**Planning Department
Transportation Development Services**

**Re: Lamar Albuquerque
1600 Airtech Court
Traffic Circulation Layout**
Engineer's/Architect's Stamp dated 4-10-15 (M16-D024J1)

Based upon the information provided in your submittal received 6-26-15, the above referenced plan cannot be approved for Building Permit until the following comments are addressed:

A1.04

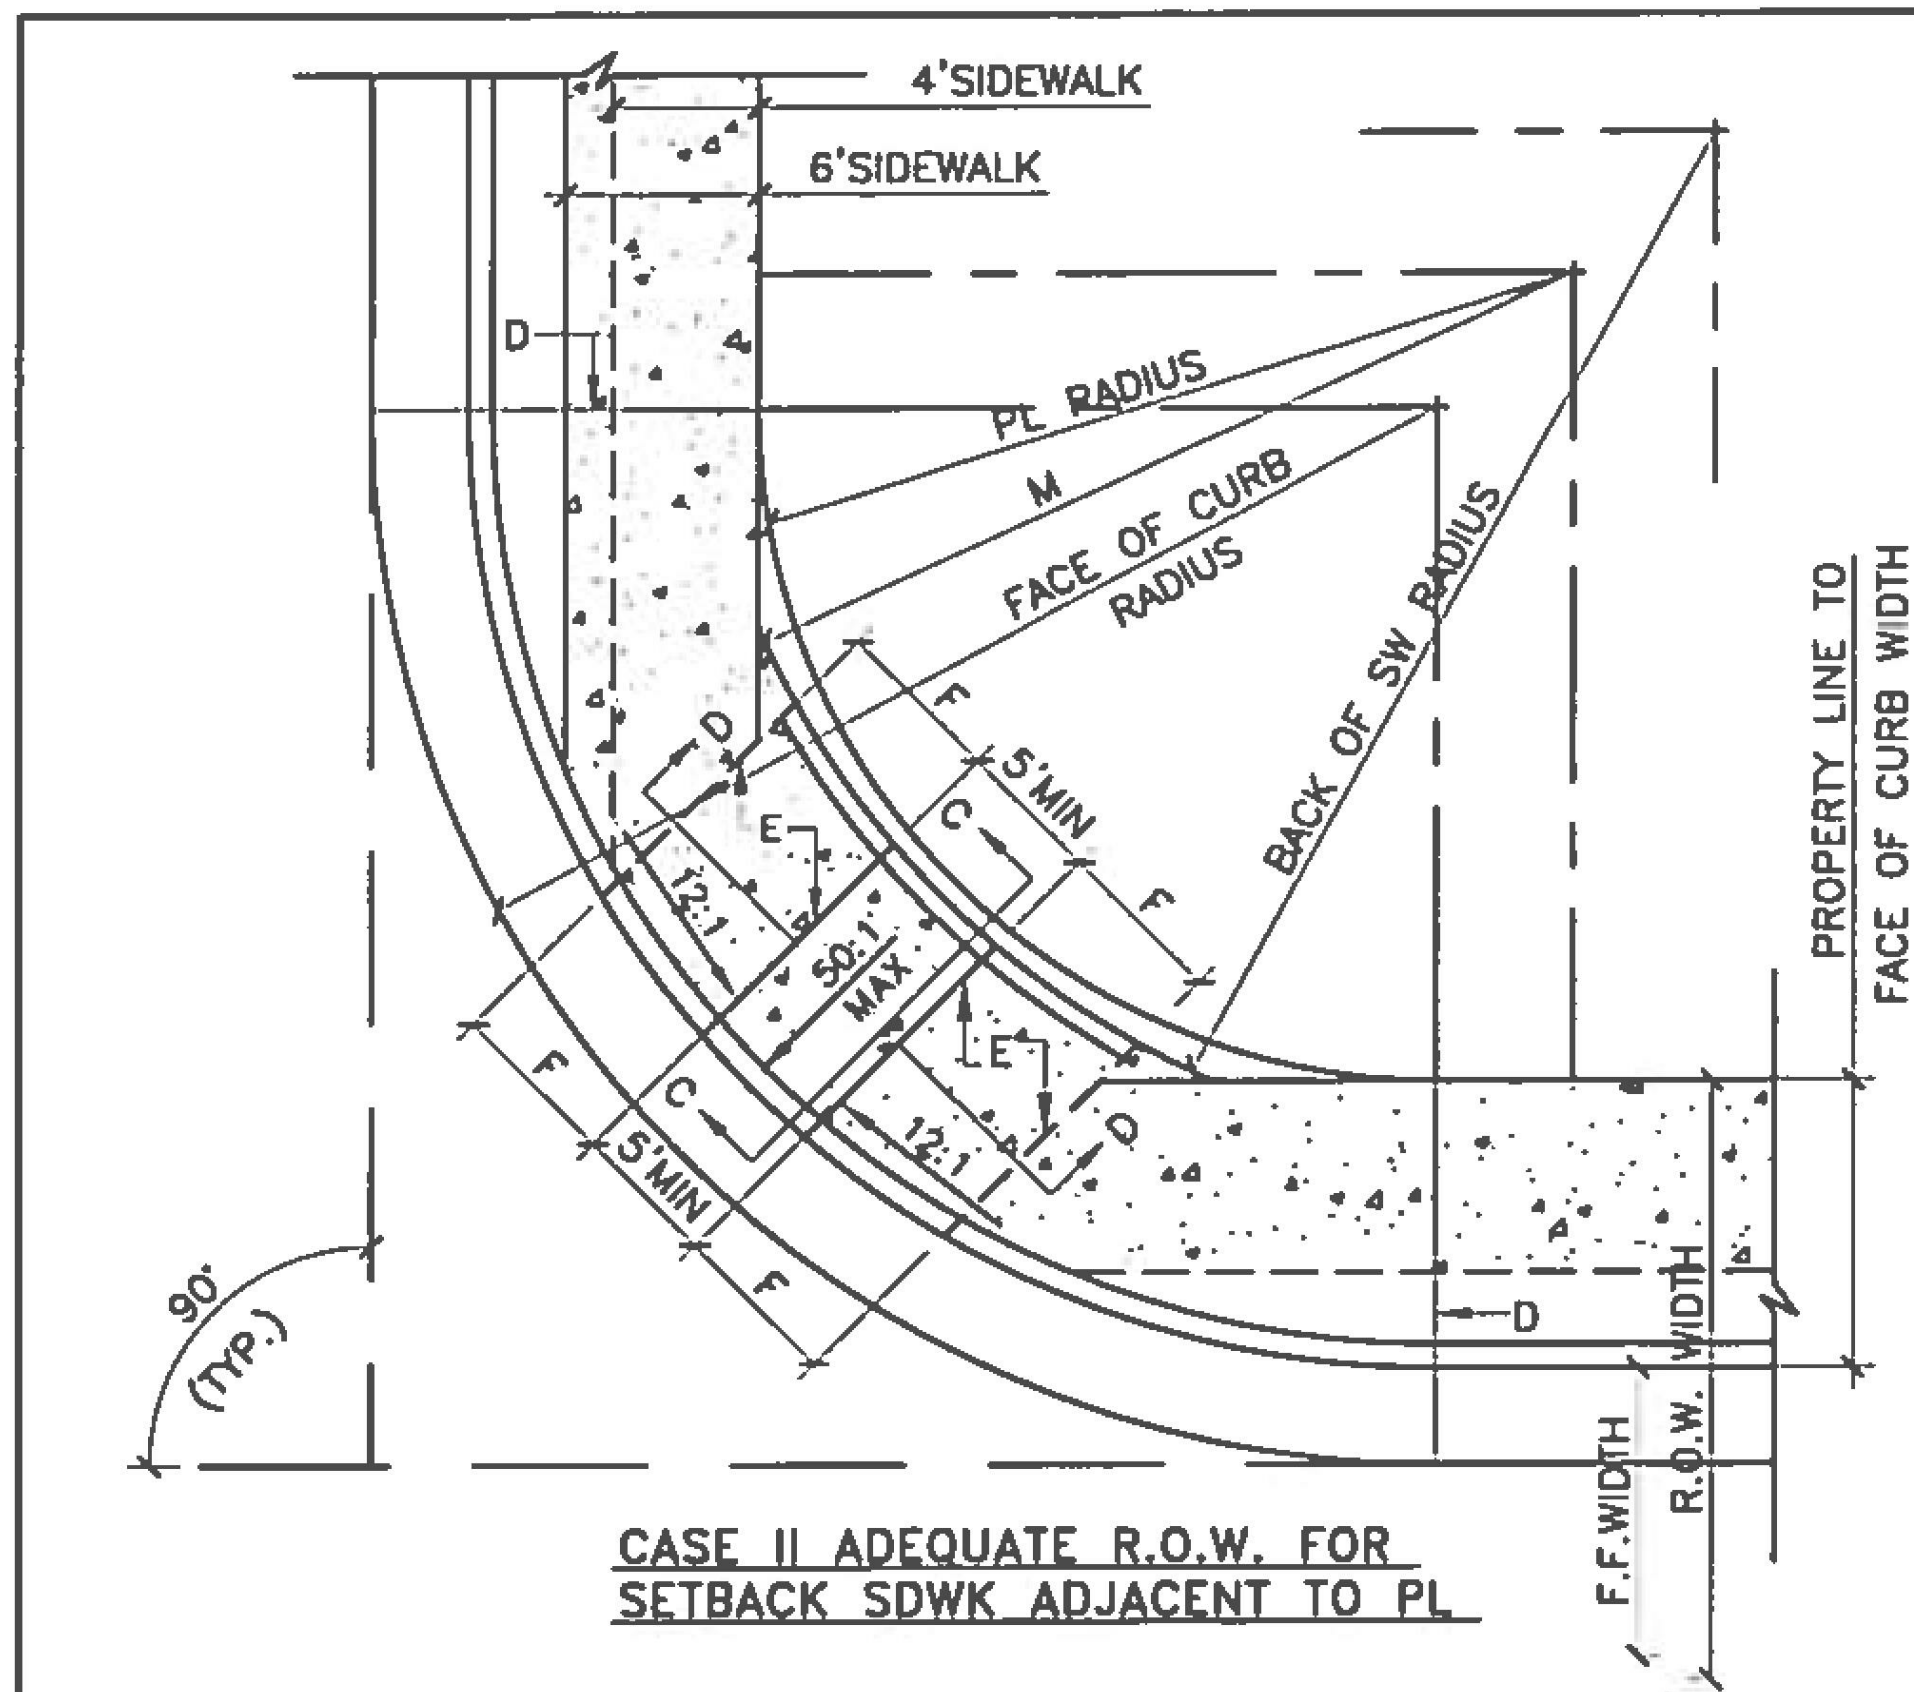
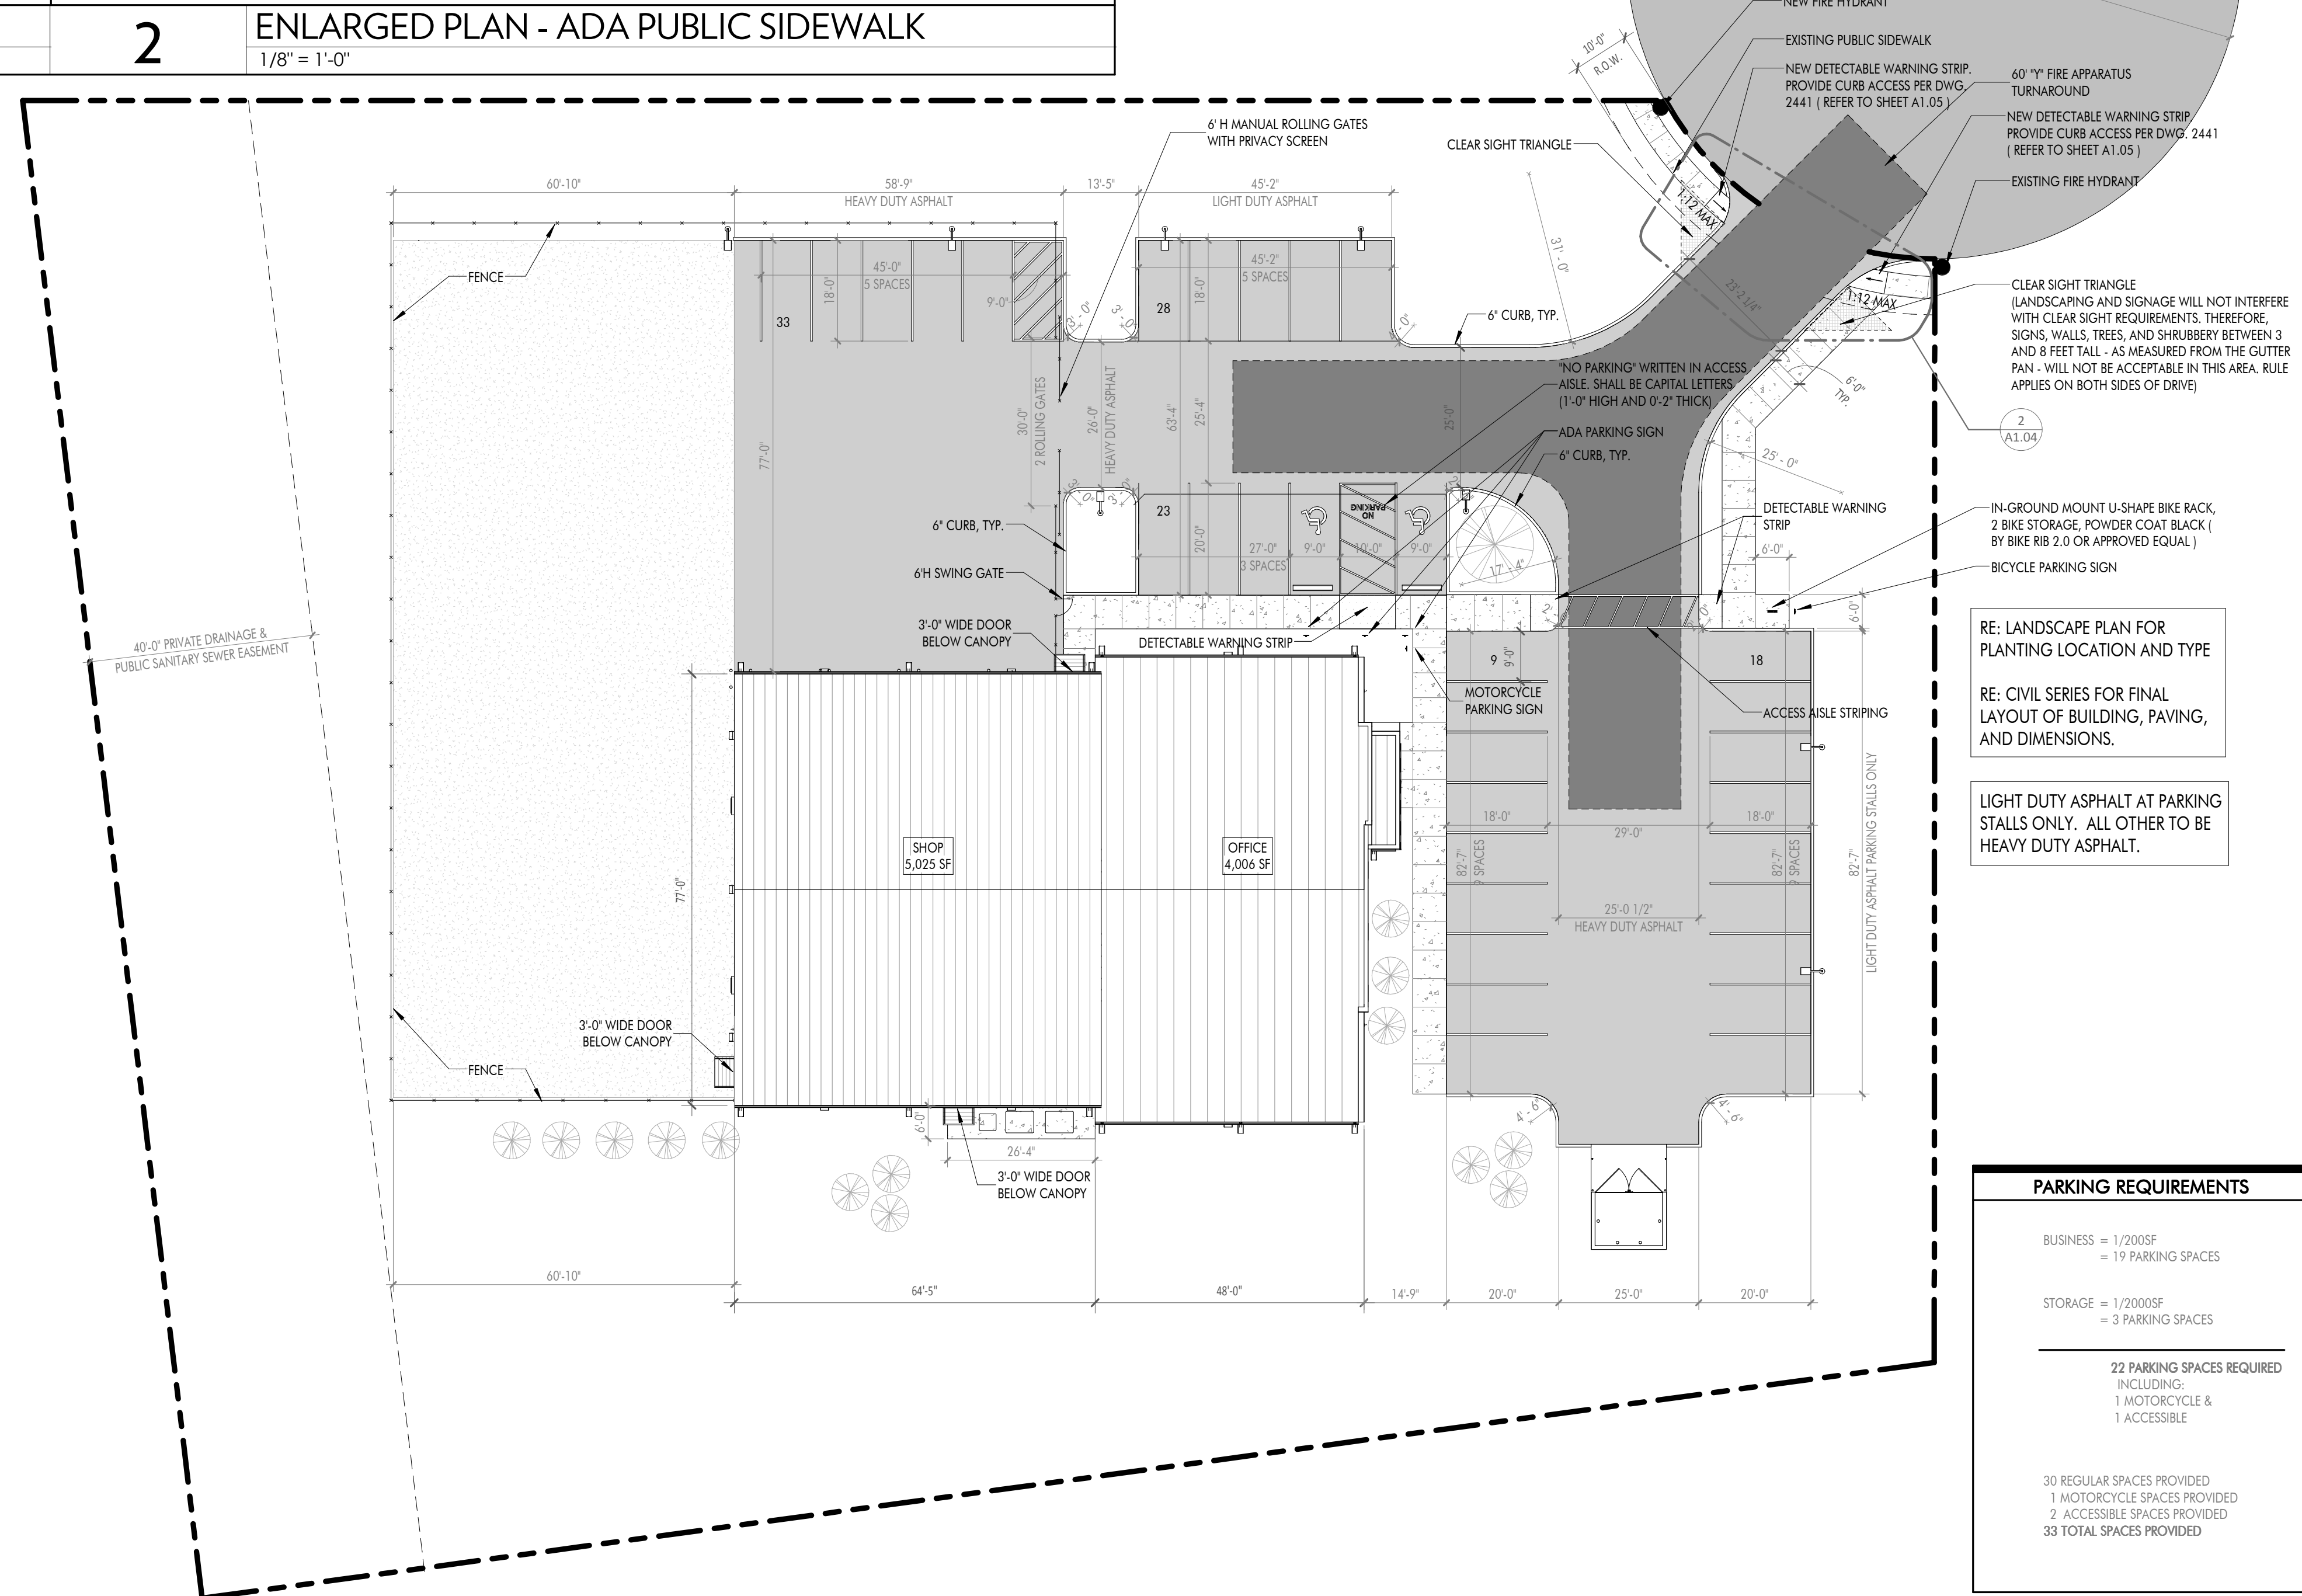
1. Please provide a Traffic Circulation Layout on one plan sheet. Our department needs to see all of the vehicle and pedestrian circulation information in one place. The following comments include information that need to be shown. We have also included a TCL Checklist for your use now and in the future.

2. Please identify all doors, structures, sidewalks, curbs, drive pads, walls and anything that influences the parking and circulation on the site.
3. Identify the right of way width, medians, curb cuts, and street width on Airtech Crt.

4. The ADA accessible sign must have the required language per 66-7-352.4C NMSA 1978 **"Violators Are Subject to a Fine and/or Towing."**
5. The ADA access aisle shall have the words **"NO PARKING"** in capital letters, each of which shall be at least one foot high and at least two inches wide, placed at the rear of the parking space so as to be close to where an adjacent vehicle's rear tire would be placed. (66-1-4.1.B NMSA 1978)

6. Show all drive aisle widths and radii.
7. Per the DPM, a 6 ft. wide ADA accessible pedestrian pathway is required from the public sidewalk to the building entrances. Please clearly show and detail this pedestrian pathway from Airtech Crt. to the building entrance. Please detail curb cut and ADA access ramps to entrance curb cut on Airtech Crt., per COA Standard Drawing 2441.

8. Per the DPM, a 6 ft. wide ADA accessible pedestrian pathway is required from the HC parking stall access aisles to the building entrances. Please clearly

show this pedestrian pathway to building entrance. It is not clear where then entrance to the building is located and if there are any elevation changes.

9. Please provide a sight distance exhibit (see the *Development Process Manual, Chapter 23, Section 3, Part D.5 Intersection Sight Distance*).

10. Please add the following note to the clear sight triangle: "Landscaping and signage will not interfere with clear sight requirements. Therefore, signs, walls, trees, and shrubbery between 3 and 8 feet tall (as measured from the gutter pan) will not be acceptable in this area."
11. Please specify the City Standard Drawing Number when applicable.
12. Work within the public right of way requires a work order with DRC approved plans.
13. Please include two copies of the traffic circulation layout at the next submittal.
